G. WE FARM CHECKLIST

NOTES FROM FINAL REVIEW JUNE 2013

GAME FARM ESTATES CLUSTER PLAT  
A PORTION OF THE EAST 1/2 OF SECTION 32,  
TOWNSHIP 18 NORTH, RANGE 19 EAST, W.M.  
KITITAS COUNTY, STATE OF WASHINGTON

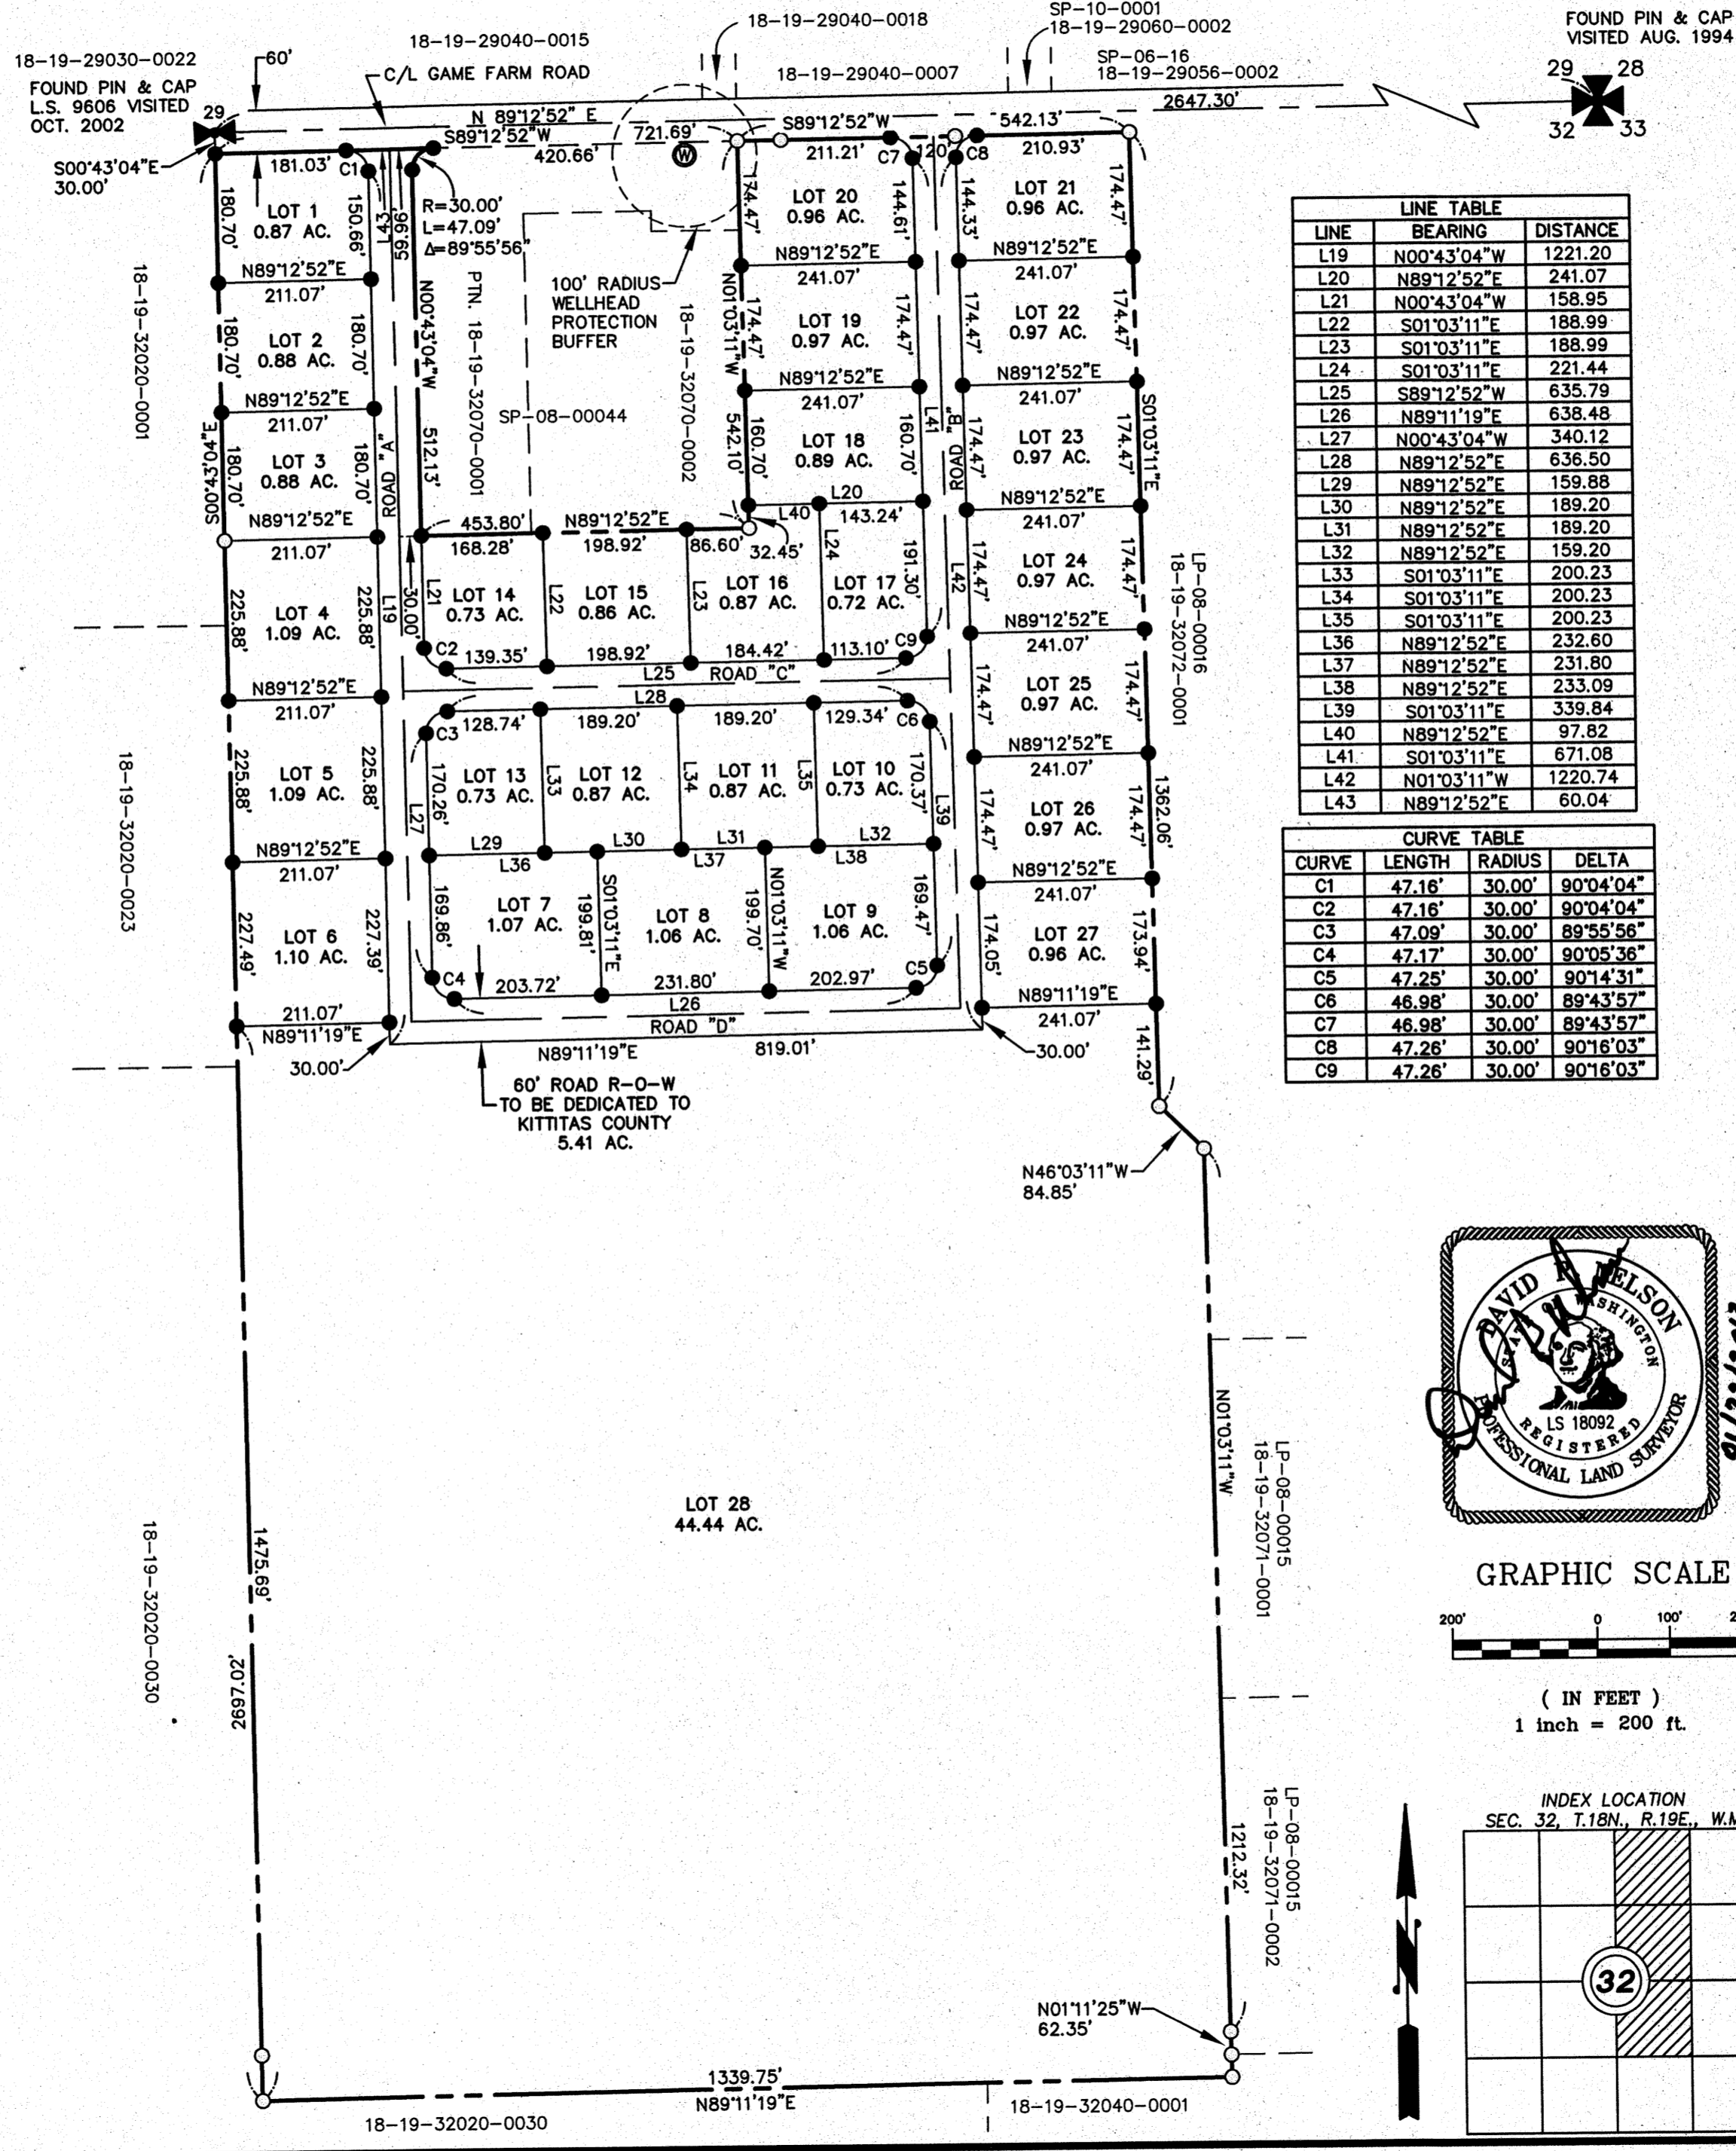
DON'T THEY HAVE TO HAVE NAMES FOR ROADS TO BE FINAL? WE HAVE THE ROAD LABELS

WCC 16 19.030 REQUIRES FACES OPEN SPACE - 5 IS(A)
WATER SOURCE WHERE IS RES. A DESIGNATED ON PLAT
